MEMORANDUM

DATE: June 14, 2024

RE: Traffic Memorandum for Rolling Thunder WD Building – Special Use
Peyton, Colorado

Figure 1 - Roadway Network

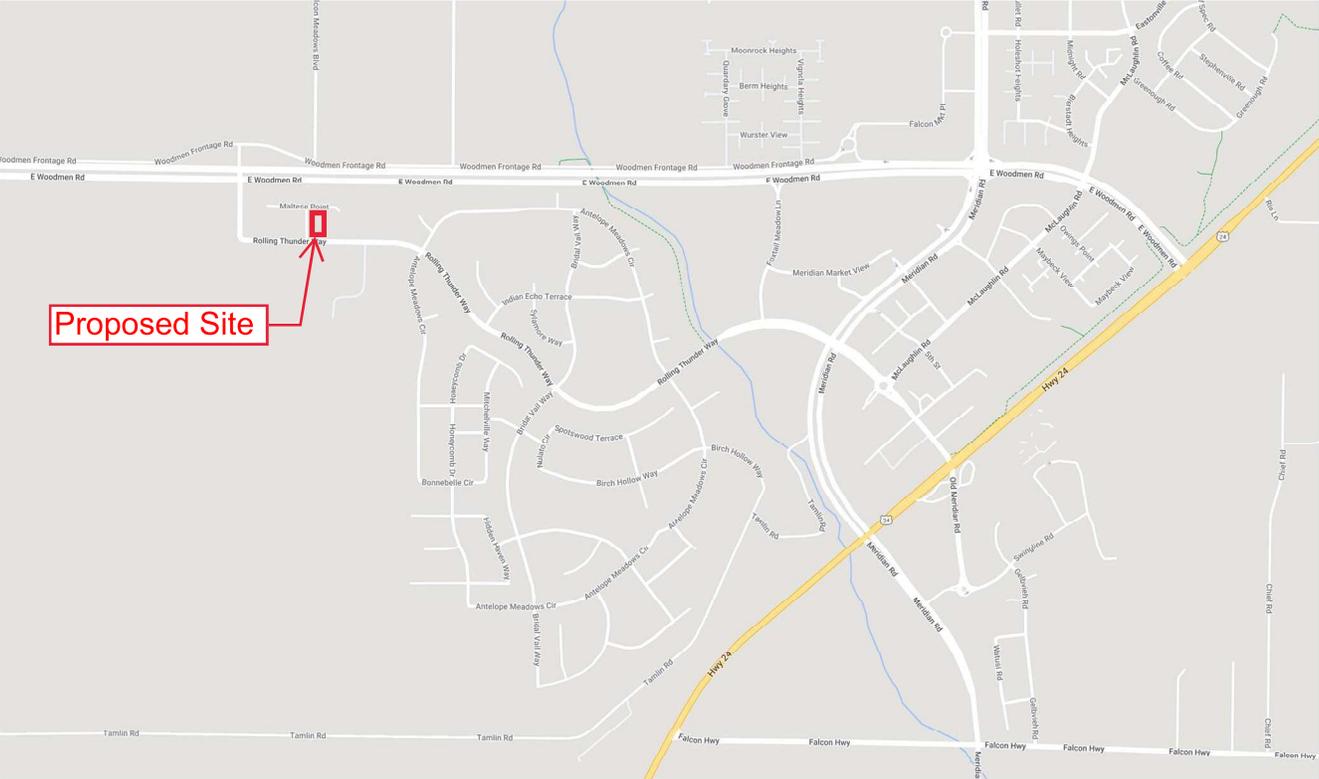
The proposed western access point on Firehouse View is approximately 116' south of the intersection with Maltese Point. Firehouse View meets Rolling Thunder Way to the south at a stop-controlled T-intersection. See **Figure 1** for the roadway network exhibit.

Land Existing traffic and intersection LOS needs to be discussed. This may include a reference to PCD file No. PUD203 for a recent TIS for existing traffic volume and intersection LOS with appropriate inflation applied or discussion included

Include the classifications of the private roads

Please include the classification for Rolling Thunder
